### Application for Planning Permission

**Development:** Erection of a single storey rear extension. This application is in CIL zone 4 (zero rated) as other development.  
**Location:** 154-160 The Street Rustington BN16 3DA

Job Address	
154-160 The Street, Rustington BN16 3ZZ	
Removing load-bearing walls	
Drawing Title	
Existing and Proposed	
First Floor Plans	
Scale	1:100 @ A3
Date	5 Sept 2025
Drawn By	WI
Drg. No	12567/02
Rev.

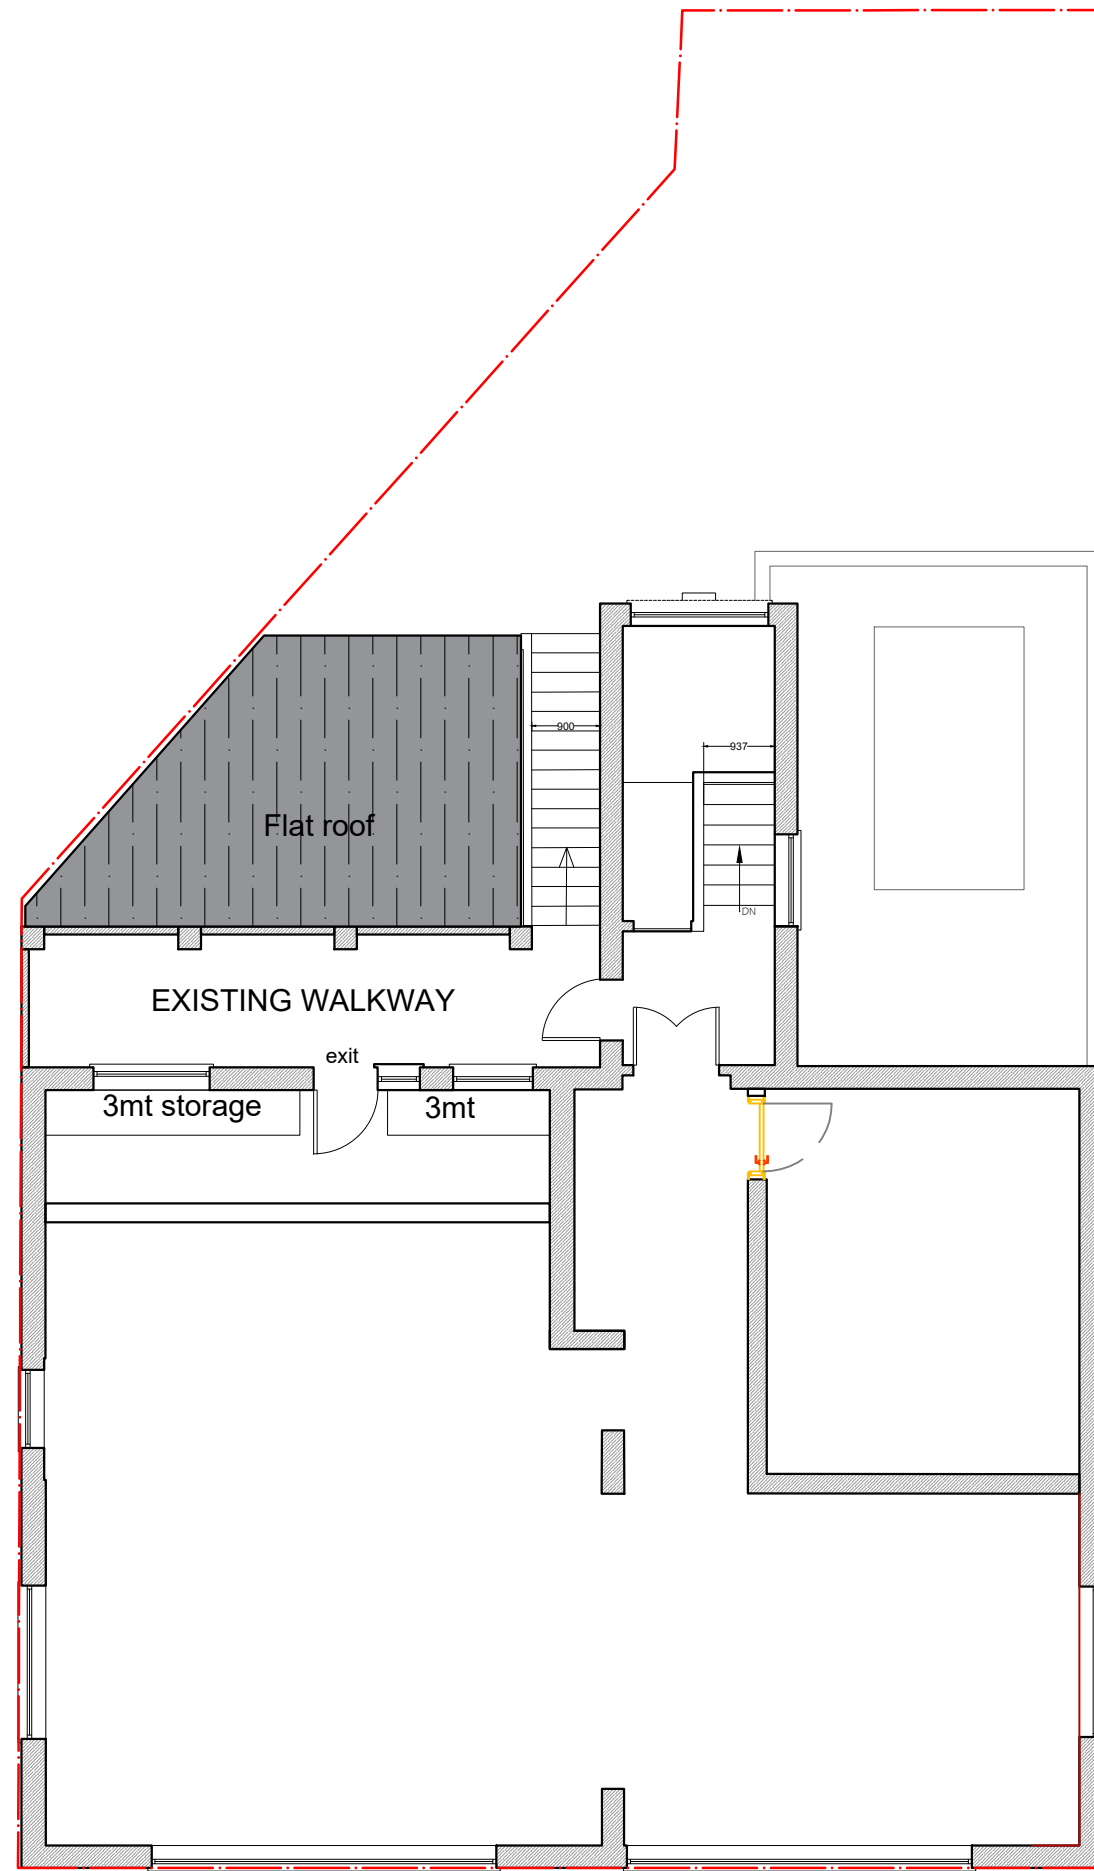
There are 2 windows shown on the existing and proposed north east elevations that are not shown on the existing and proposed first floor plan. Please amend accordingly and resubmit.

Job Address	
154-160 The Street, Rustington BN16 3ZZ	
Removing load-bearing walls	
Drawing Title	
Existing and Proposed Ground Floor Plans	
Scale	1:100 @ A3
Date	5 Sept 2025
Drawn By	WI
Drg. No	12567/01
Rev.

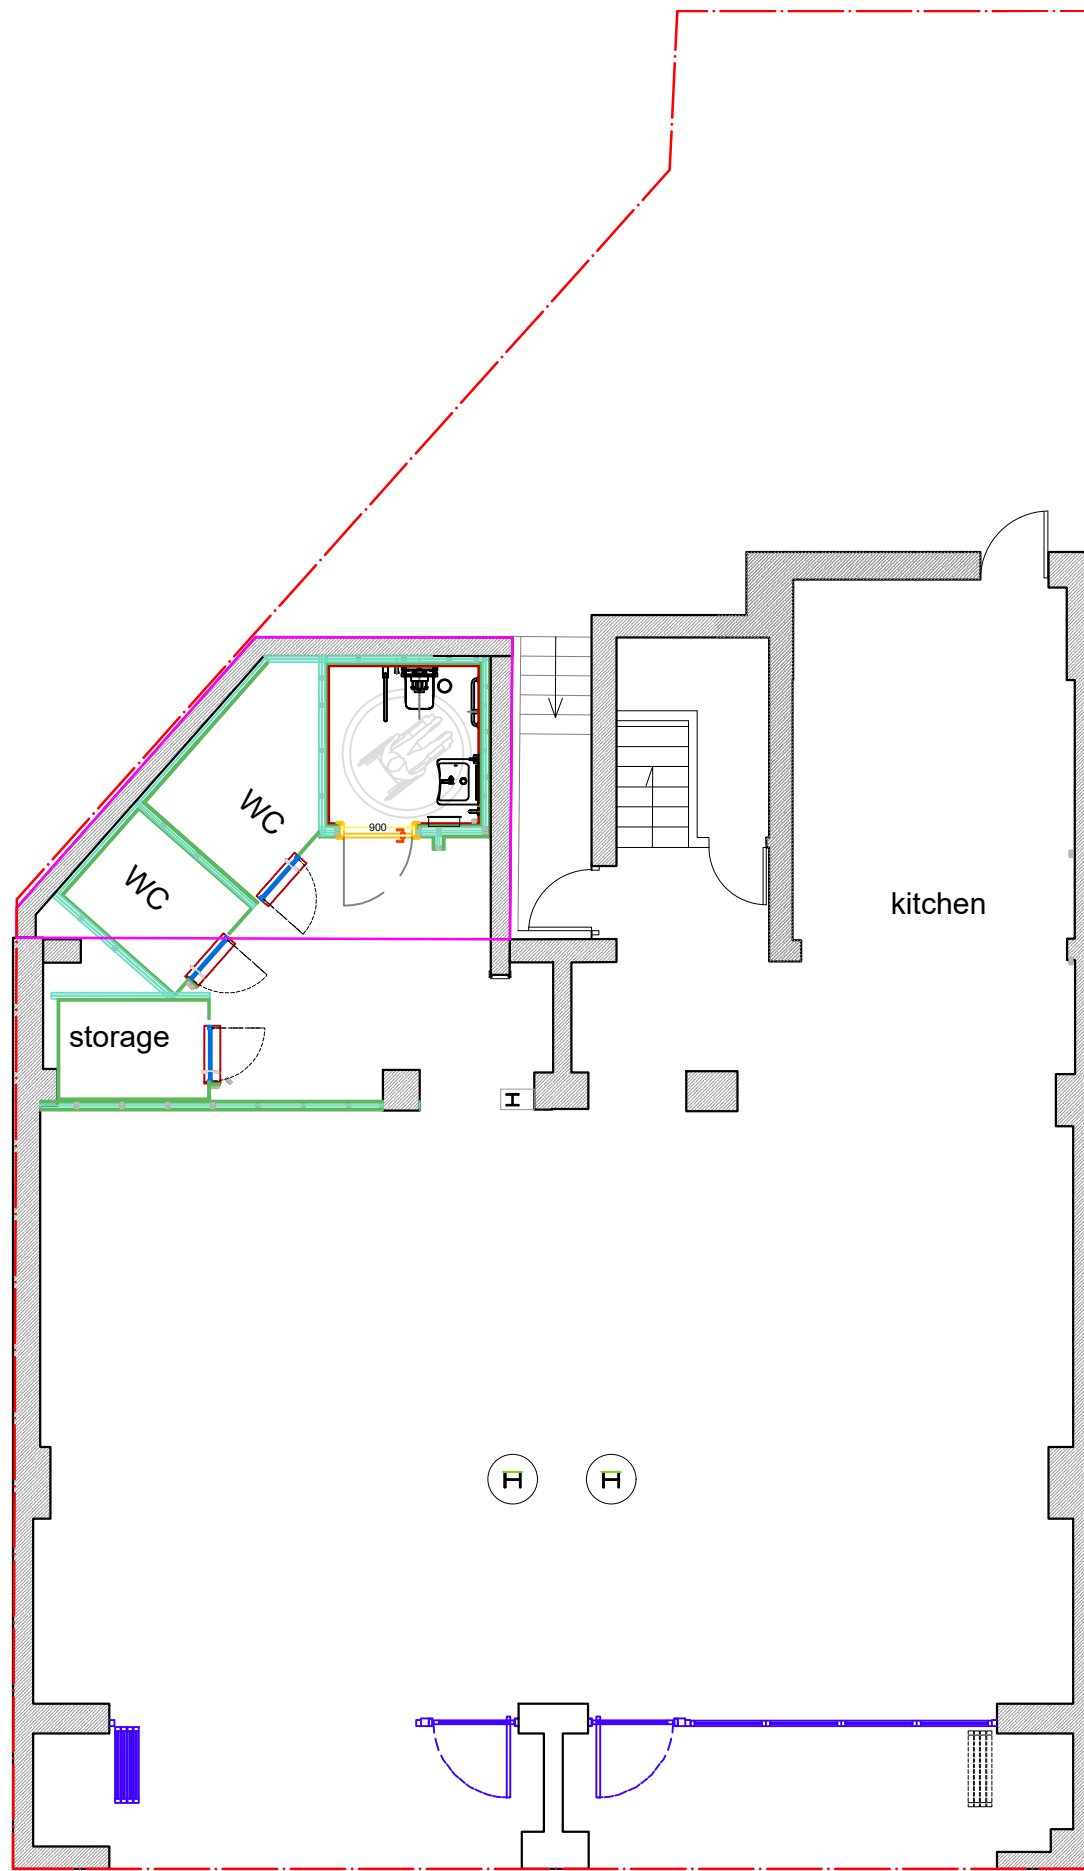
The door shown on the existing and proposed rear elevations is missing on the existing and proposed ground floor plans. Please amend accordingly and resubmit.
